Garrane Green Energy Project Limited
ACP-323635-25

9 no. wind turbines, grid connection, an energy storage facility and all associated site works.
Ballynagoul, Creggane and Garrane, County Limerick.

Re: Notification under the Planning and Development Act, 2000, as amended.

Proposed Strategic Infrastructure Development (SID): REDIII Application 9 no. wind turbines, grid connection, an energy storage facility and all associated site works at Ballynagoul, Creggane and Garrane, County Limerick.

Daylight / Emergence Survey Locations

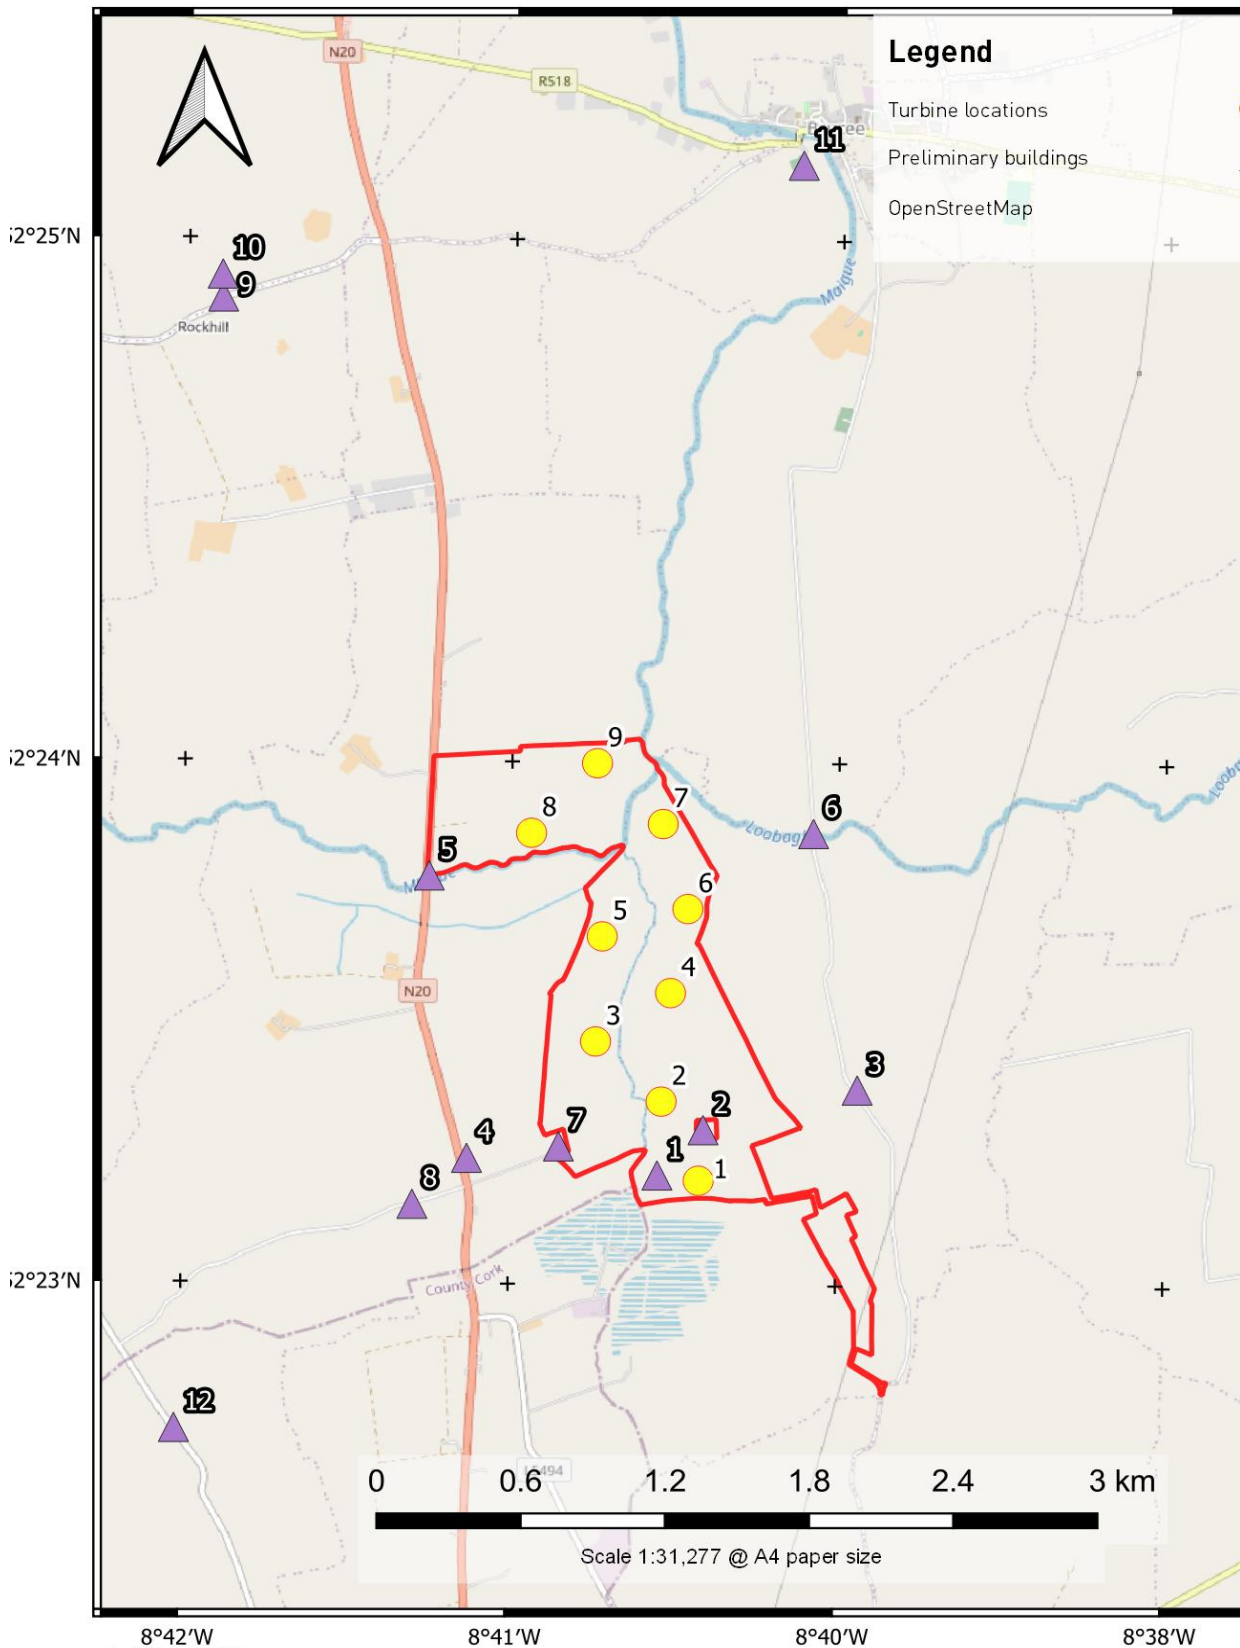
noted that during an activity survey at roost structure 2 (the closest such structure to the Lesser Horseshoe record) an unidentified bat was observed which did not trigger the recorder. While this could have been, for example, a Brown Long-eared Bat, which also has a narrow recorder-detectable range, there is the possibility that it was a Lesser Horseshoe. In any case, the Lesser Horseshoe record should have triggered a comprehensive and targeted survey of Lesser Horseshoe usage of the site; including commuting routes and use of the buildings, throughout the year. However, an October survey was not carried out in 2023, and the static detector for T1 was deployed in a different location; no detailed static detector survey of the hedgerows in this area was carried out.

Figure 7-1: Removal of hedgerows and treelines

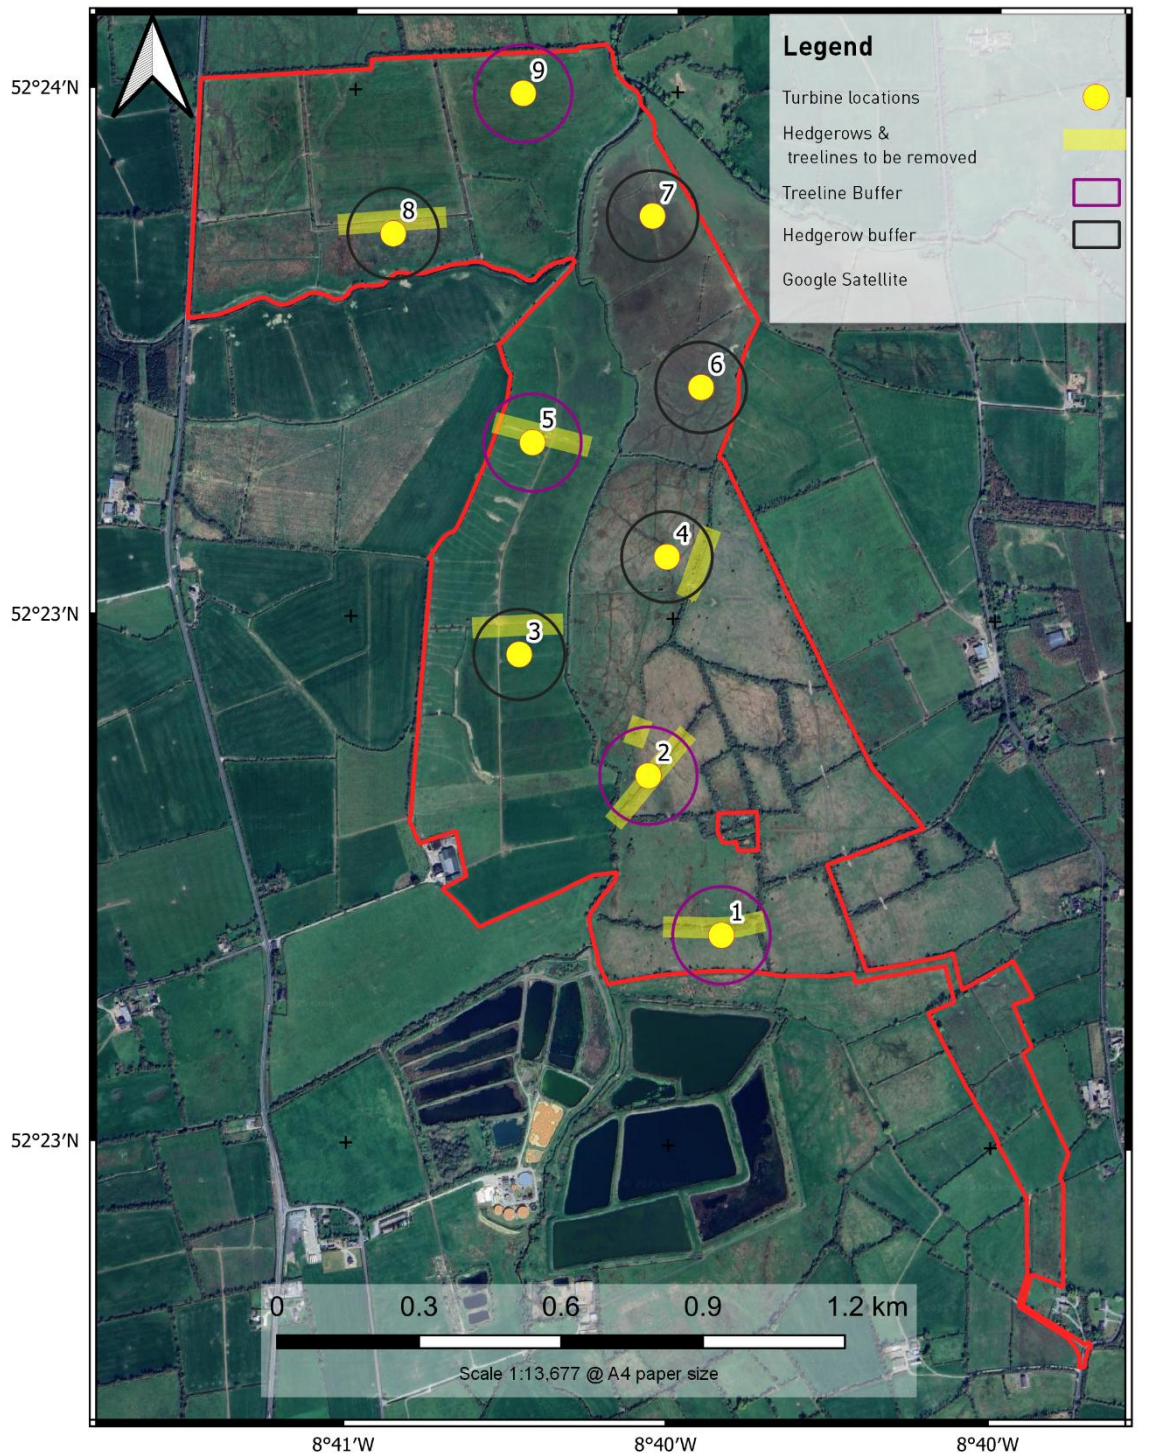
It would be very important that Lesser Horseshoe commuting routes and usage of the area is established, due to the significant degree of hedgerow and treeline removal proposed. Although replacement planting is planned, this will be in different locations, and in the absence of more detailed information, there is the risk that isolation of a roost (particularly in relation to structure 2), or severing of a significant commuting route, may occur. Replacement planting will also take several years to develop into an effective and sheltered commuting route.
